**Subject:** Rezoning Petition Review

**Date of Review:** April 28, 2022

**Rezoning Petition #:** 21-258

**Location of Property:** Approximately 64.05 acres located along the north side of University City Blvd, east of Neal Rd, west side of I-85 and south of IBM Dr.

REZONING SITE PLAN

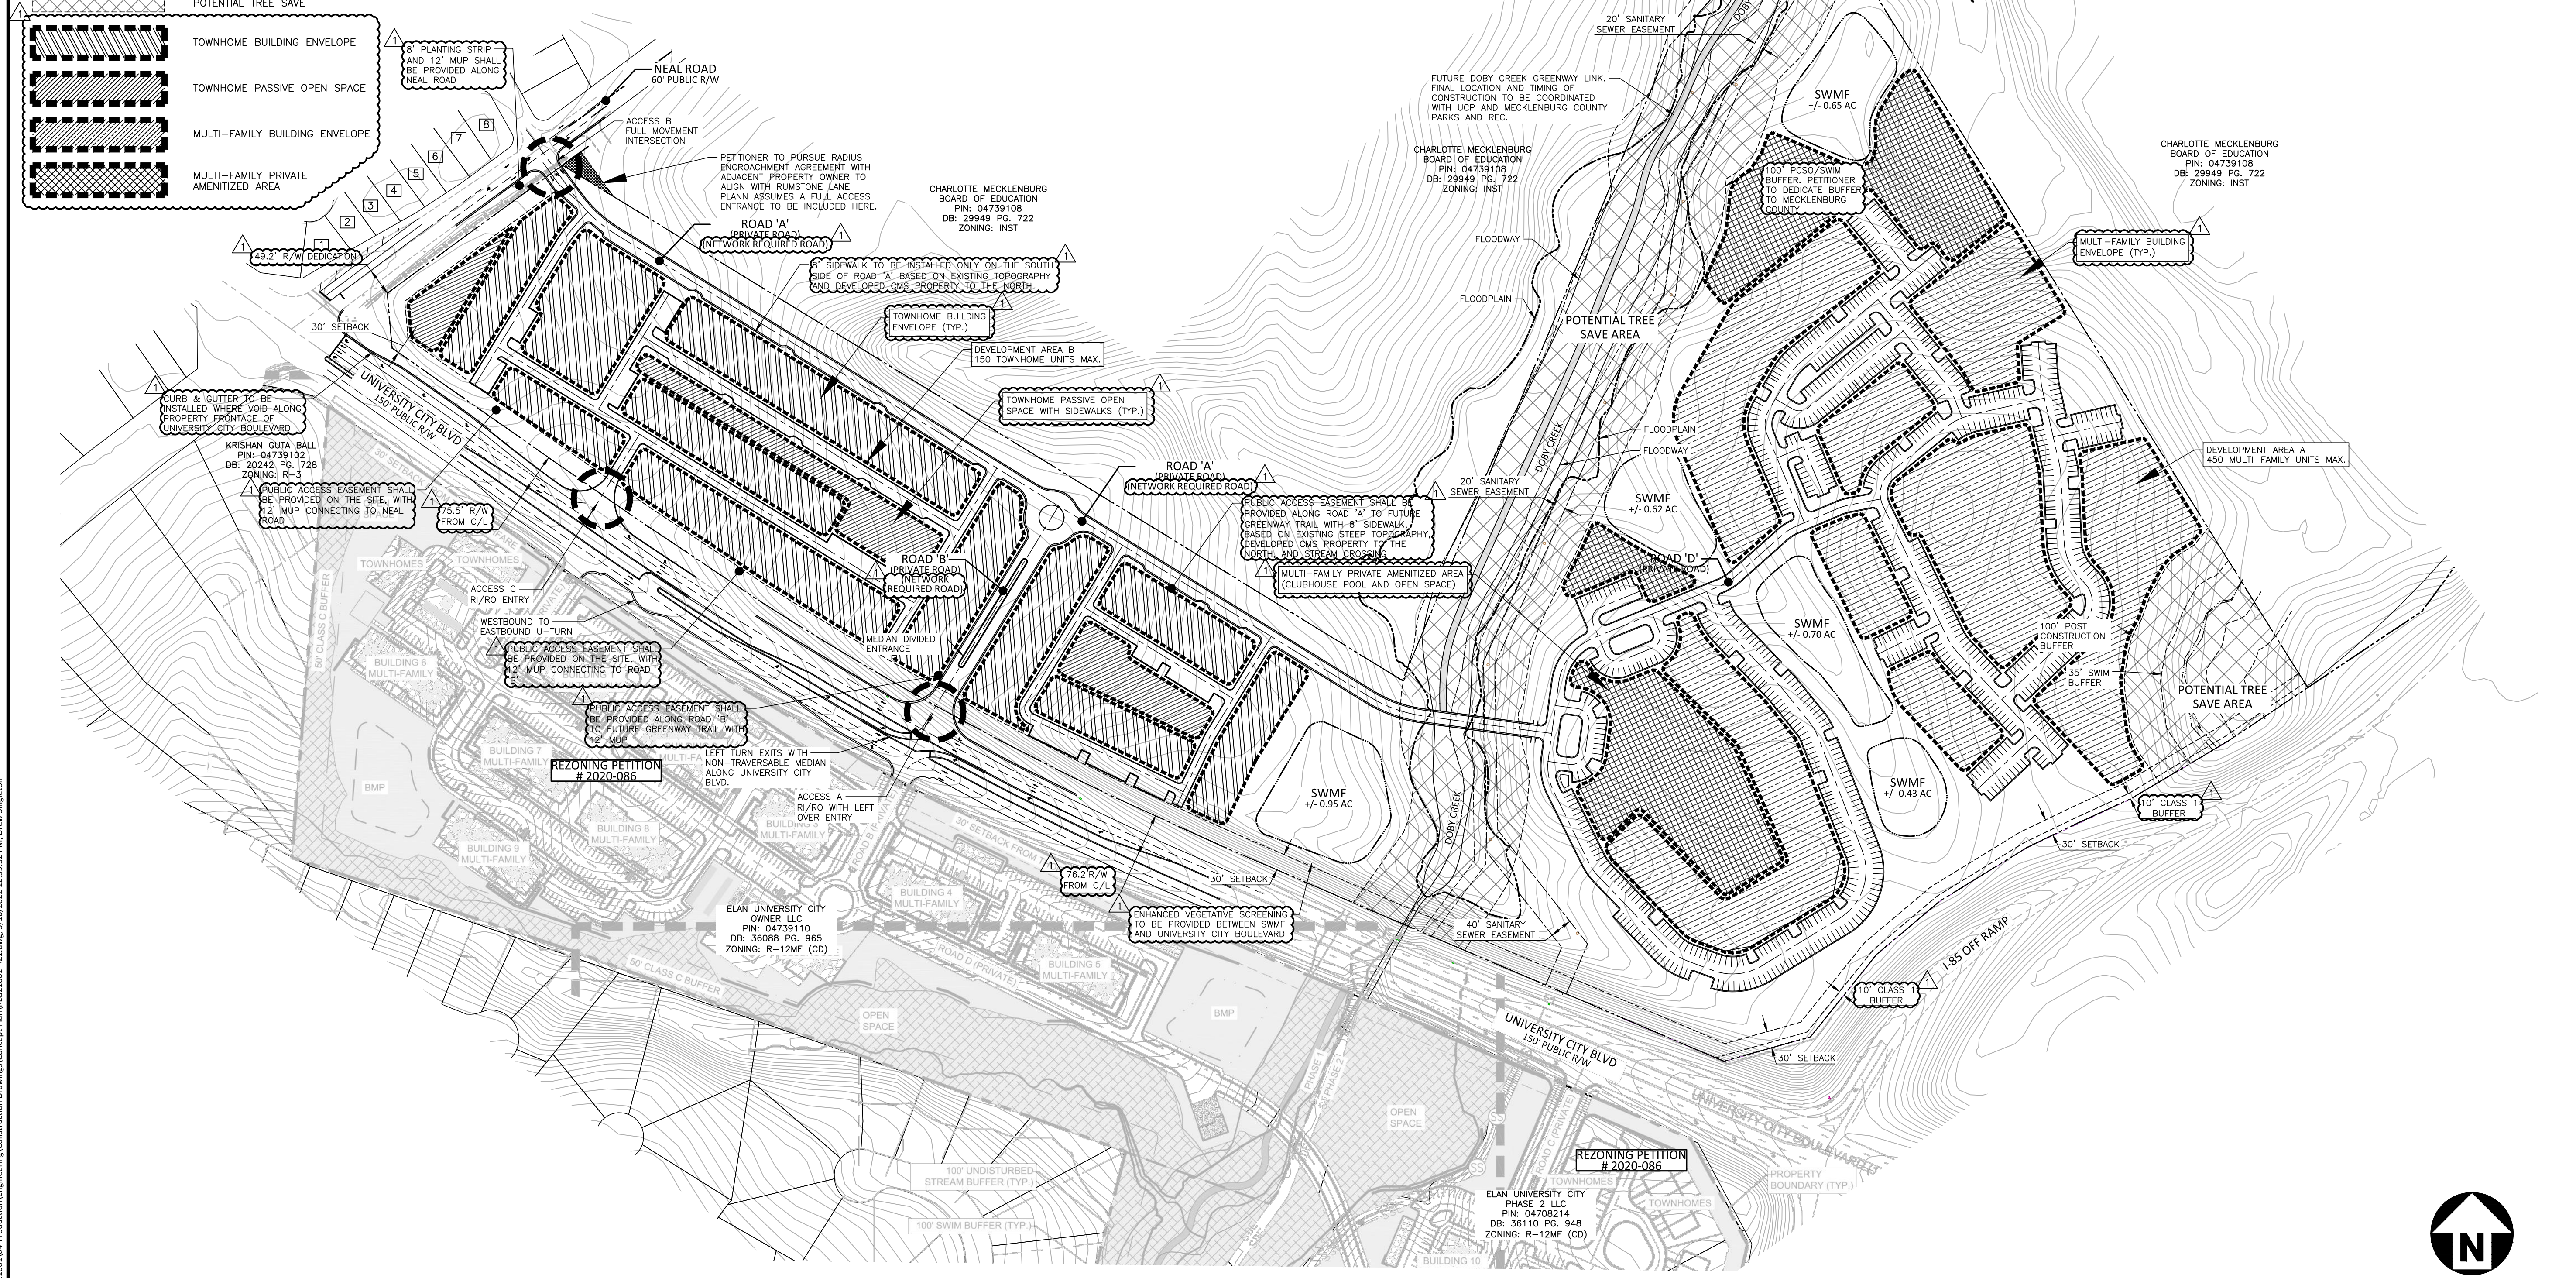
The proposed rezoning plan sheet indicates a proposed location for storm water management. Please include the following notes on the plan sheet under "Environmental Features": *The location, size, and type of storm water management systems depicted on the Rezoning Plan are subject to review and approval as part of the full development plan submittal and are not implicitly approved with this rezoning. Adjustments may be necessary in order to accommodate actual storm water treatment requirements and natural site discharge points.*
